**From:** Contact Centre (CRM) <contact@ribblevalley.gov.uk>  
**Sent:** 16 February 2022 20:31  
**To:** Planning  
**Subject:** Planning Application Comments - 3/2021/0789

**Planning Application Reference No.:** 3/2021/0789

**Address of Development:** 46 Eshton Terrace, Clitheroe, BB7 1BQ

Mr & Mrs Morley		
46 Eshton Terrace, Clitheroe		
Plans and Elevations as Proposed		
Scale		1:50 & 1:100 @ A1
Drawn	Checked	Approved
DME		
Drwg No.	A3343/PL05	
Date	July 2021	
Rev.

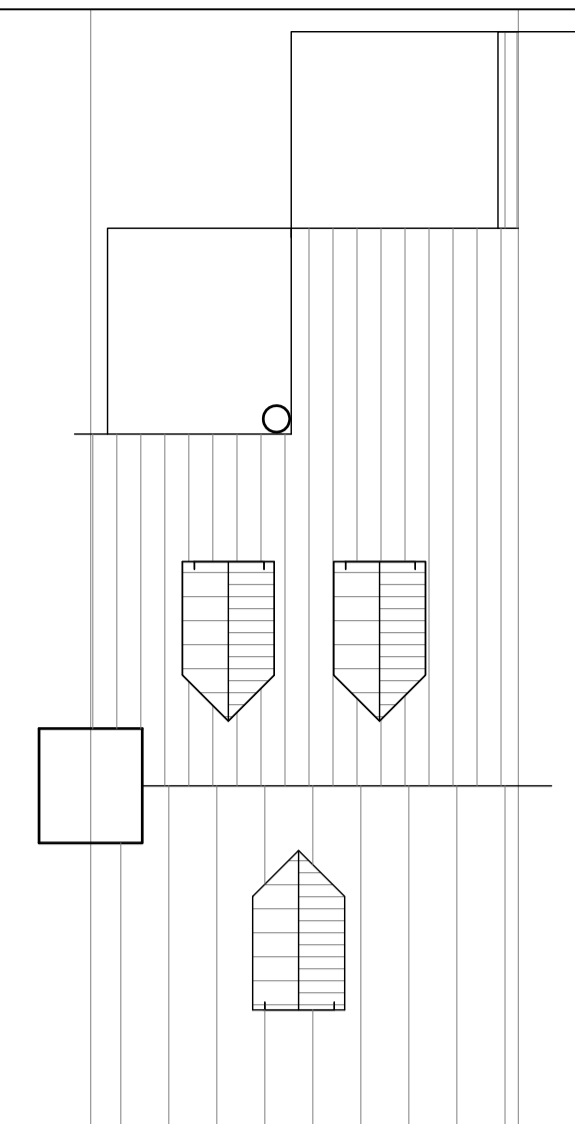
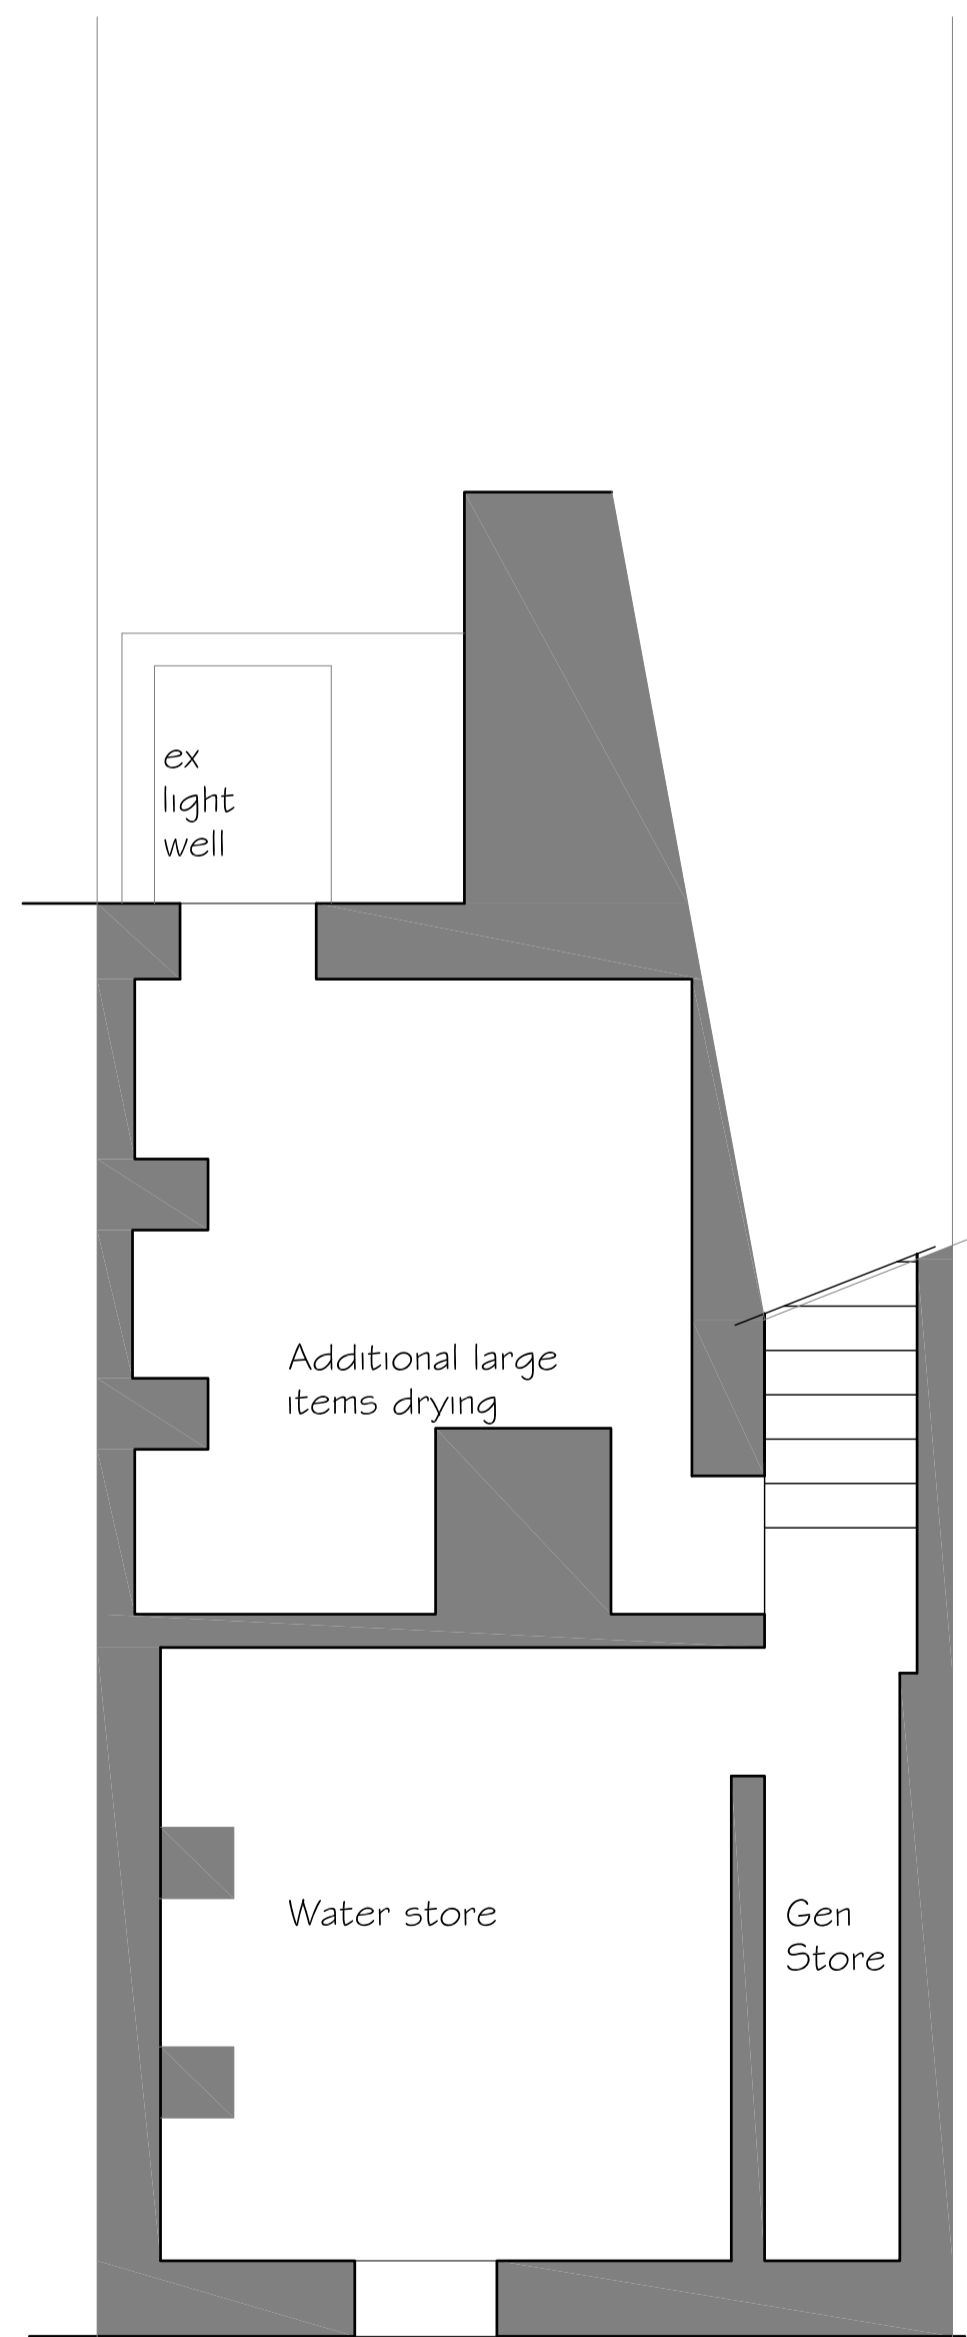
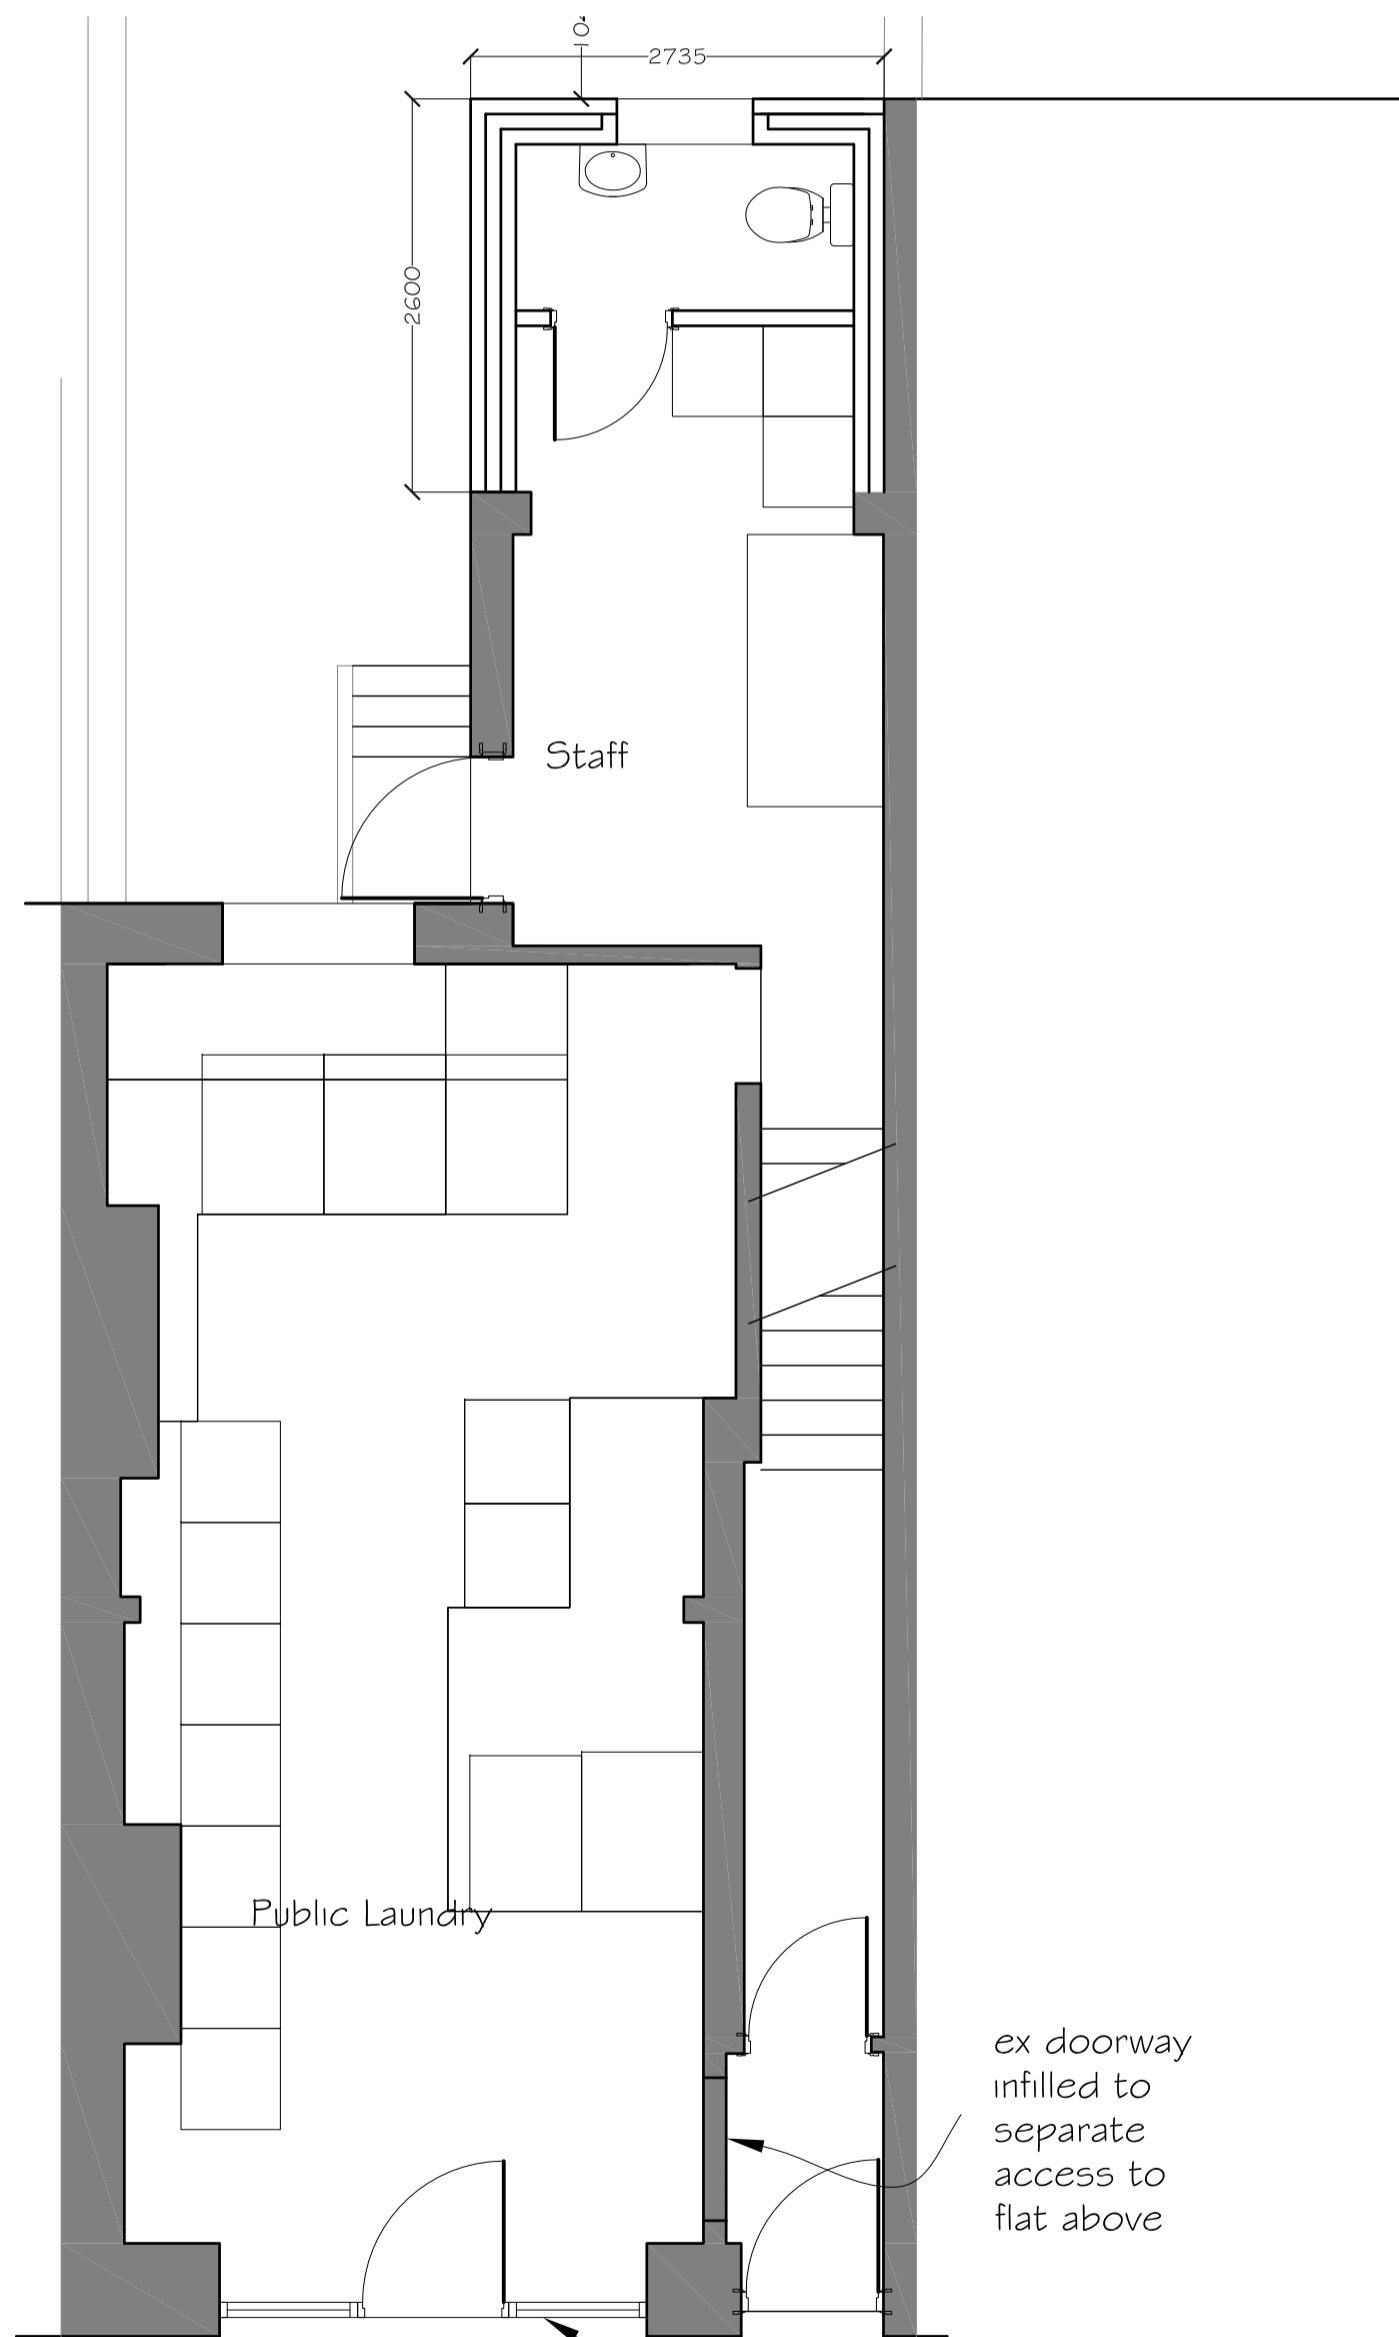
**Comments:** Further to the notice of Amended Information Received: I understand that the amendments are shown on an amended proposed plan which now show (1) a conservation style rooflight and dormer window rather than x2 dormer windows (2) a door to the left side of the existing window rather than extending the window to close to ground level with a central door. Unfortunately these changes diminish the historical pattern of door and windows to a greater extent than the original proposed plans. In the case of (1) the windows in the rear facing roof - the twin dormers at least would be recognisable as being for the same property whereas mixing the types of rear roof windows will confuse the remaining appearance of the whole. Two dormers would match the property at [REDACTED]. Two rooflights would offer minimal disruption and might therefore be superior but aren't proposed. Two different forms offers the most disruption to the remaining historical appearance of the rear roof of this section of terrace. In the case of (2) the amended additional front door arrangement the impact is similar - the original proposal was clearly distinct from the existing pattern of front doors and garden paths and was both modern and visually attractive positively balanced against the impact to the existing rhythm of door ways. As there is no additional information added to the design statement I cannot understand the thinking behind the re-design of a doorway to the left of a window - presumably the existing window. The result on the plan looks irregular and jarringly discordant and creates the appearance of a door stuck into a building without any regard to the existing form of the terrace or its appearance. I believe both of these amendments proposed detract from remaining history in the appearance of this section of terrace. Please consider these comments in addition to my previous comments on this application.
